**EPC STORMWATER REVIEW COMMENTS
 IN ORANGE BOXES WITH BLACK TEXT**

**EL PASO COUNTY
 STORMWATER MANAGEMENT PLAN CHECKLIST**

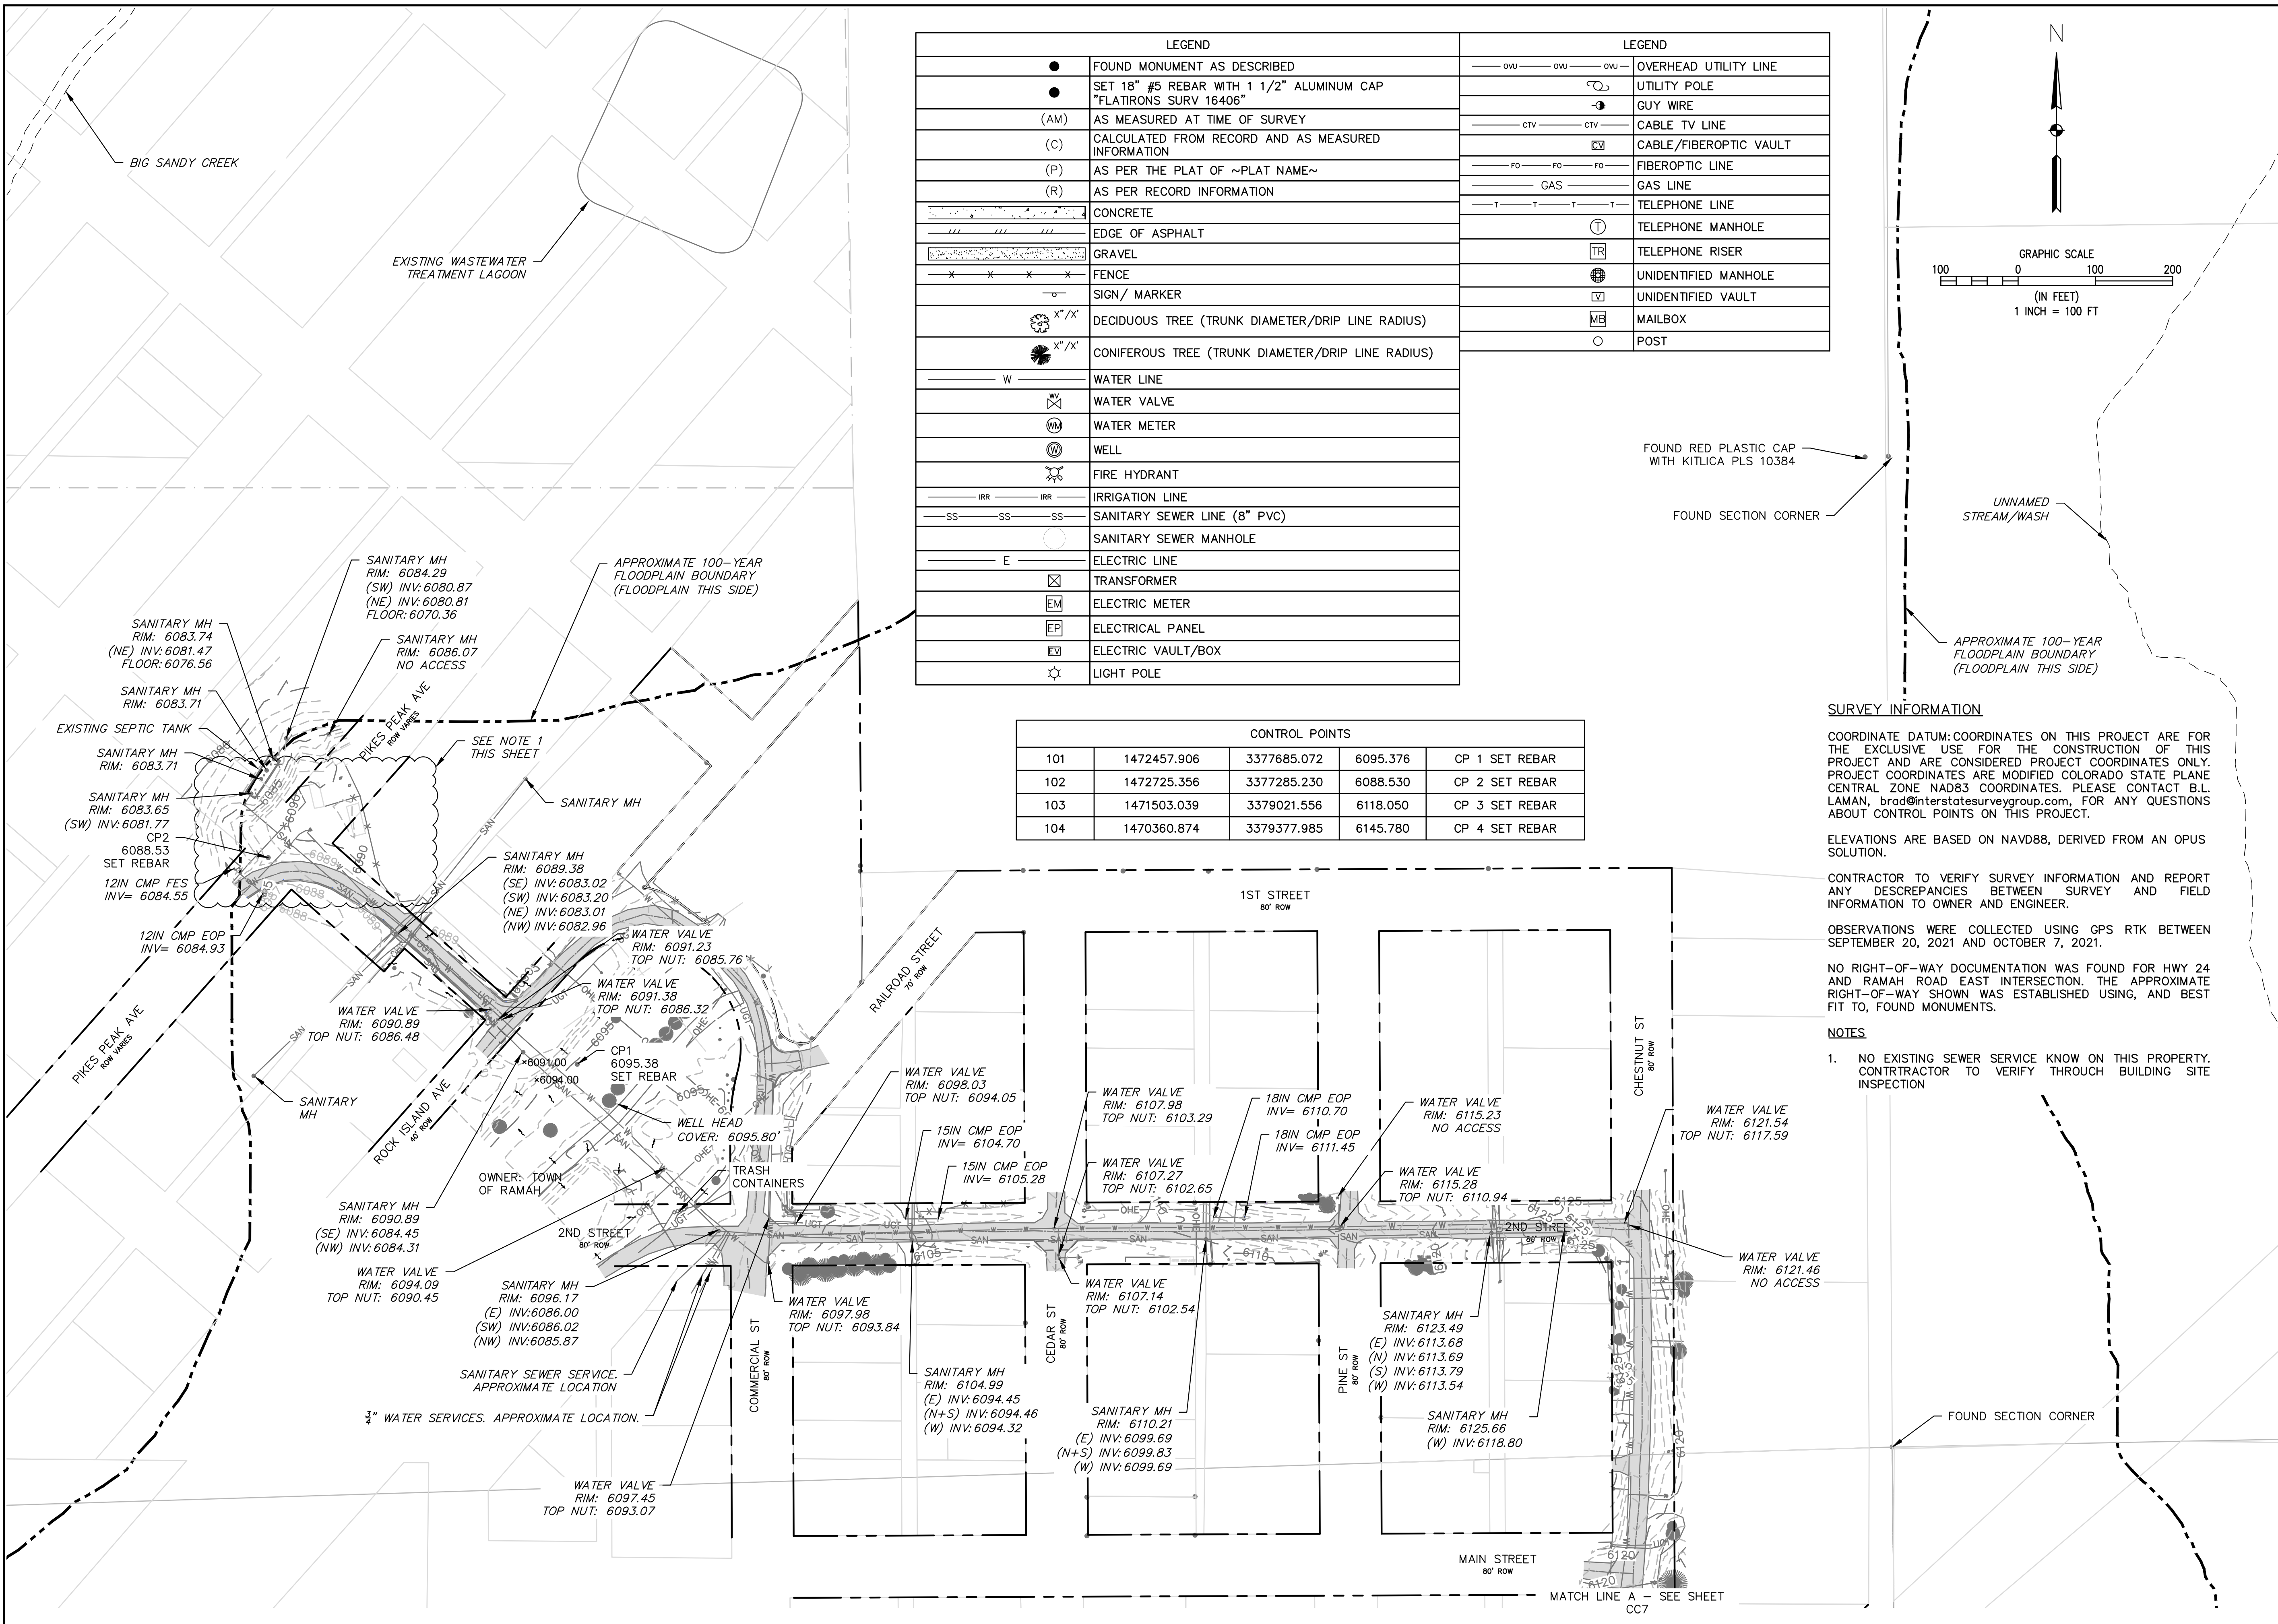
Applicant	EPC
17	SWMP Map to include:		
17a	construction site boundaries		Y
17b	flow arrows to depict stormwater flow directions		N
17c	all areas of disturbance		Y
17d	areas of cut and fill		N
17e	areas used for storage of building materials, soils (stockpiles) or wastes		Y
17f	location of any dedicated asphalt / concrete batch plants		Y
17g	location of all structural control measures		Y
17h	location of all non-structural control measures		Y
17i	springs, streams, wetlands and other surface waters, including areas that require maintenance of pre-existing vegetation within 50 feet of a receiving water		Y
18	Narrative description of all structural control measures to be used. Modifications to EPC standard control measures must meet or exceed County-approved details		Y
19	Description of all non-structural control measures to be used including seeding, mulching, protection of existing vegetation, site watering, sod placement, etc.		Y
